Your Ref: OWPC24582
Our Ref: AW/250/19/HH 30-08-2019
Please ask for:
Amber Willard

Extension to driveway to front & widening driveway gate. This application affects the character & appearance of the Craigweil House Conservation Area.

19 Kingsway Aldwick

Proposed

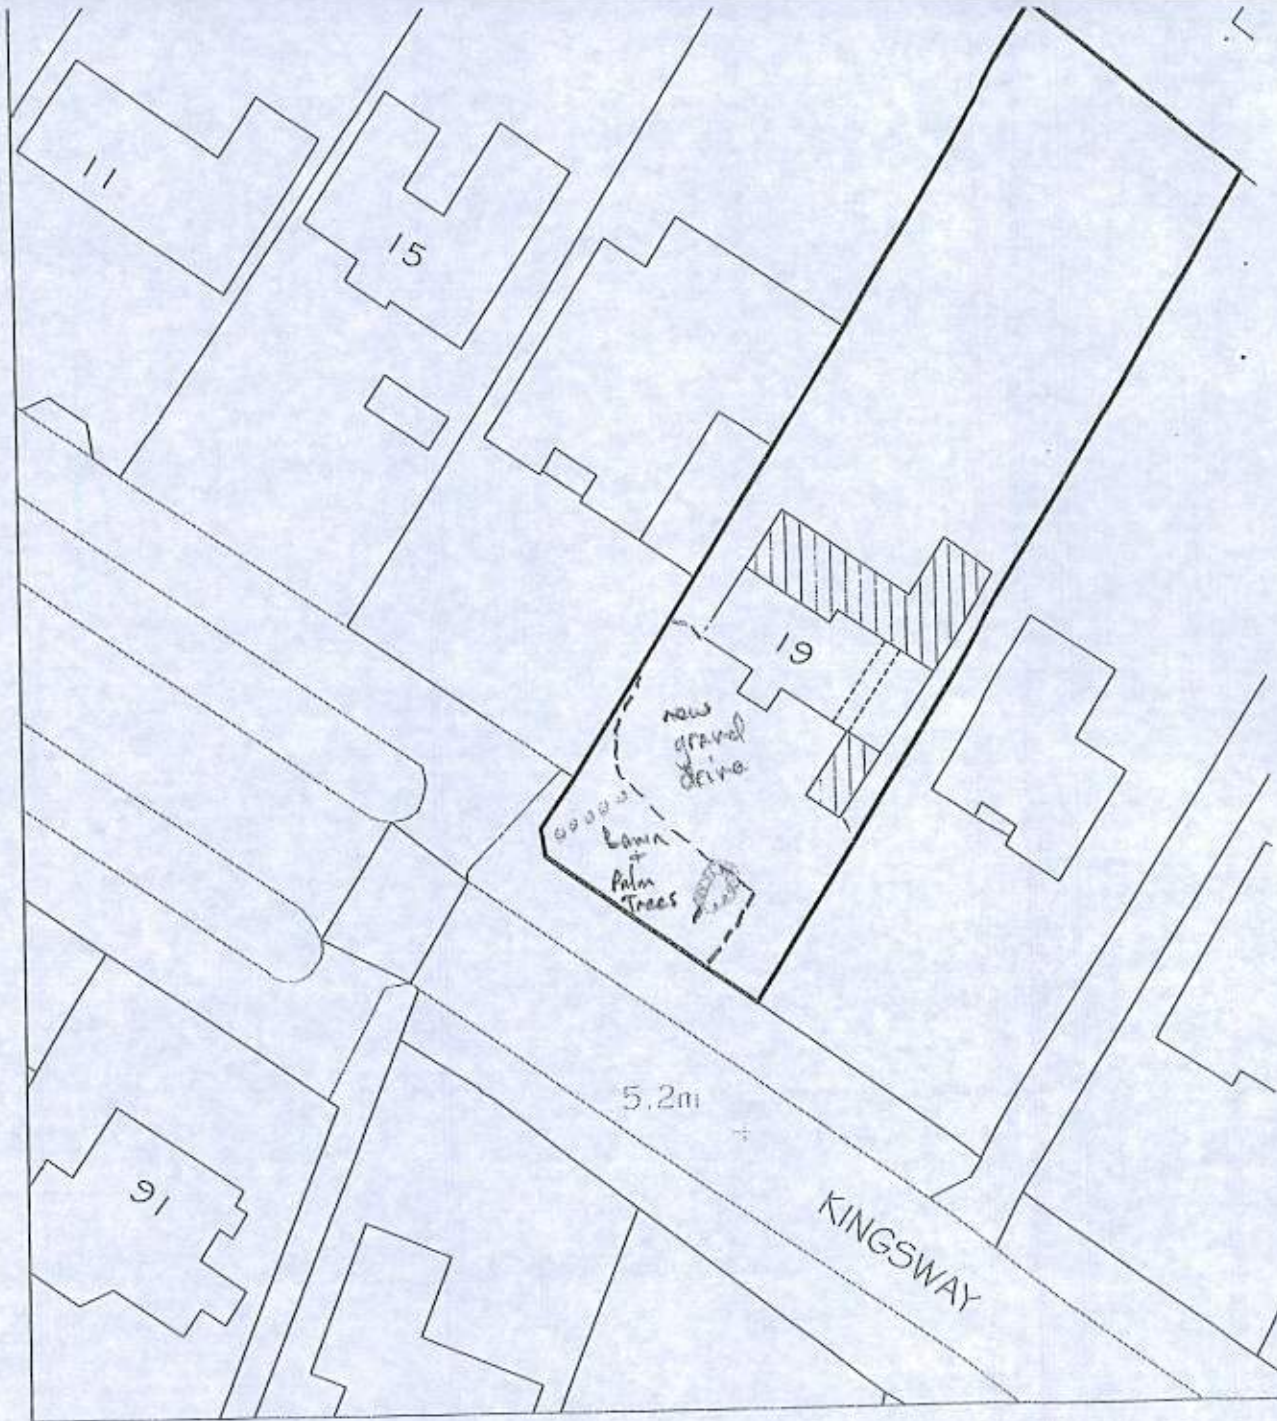
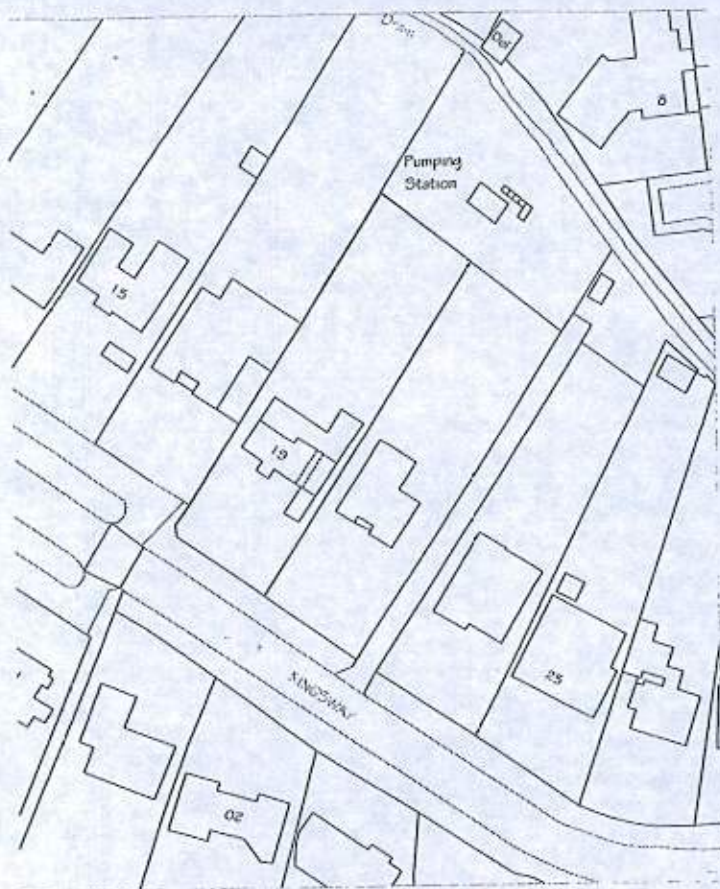
3. A proper, detailed sectional drawing is required, showing materials and thicknesses and measurements of the construction of the proposed driveway and parking area.

4. Confirmation that the existing bricks from the brick pier will be used in any new pier and that darkened mortar will be used.
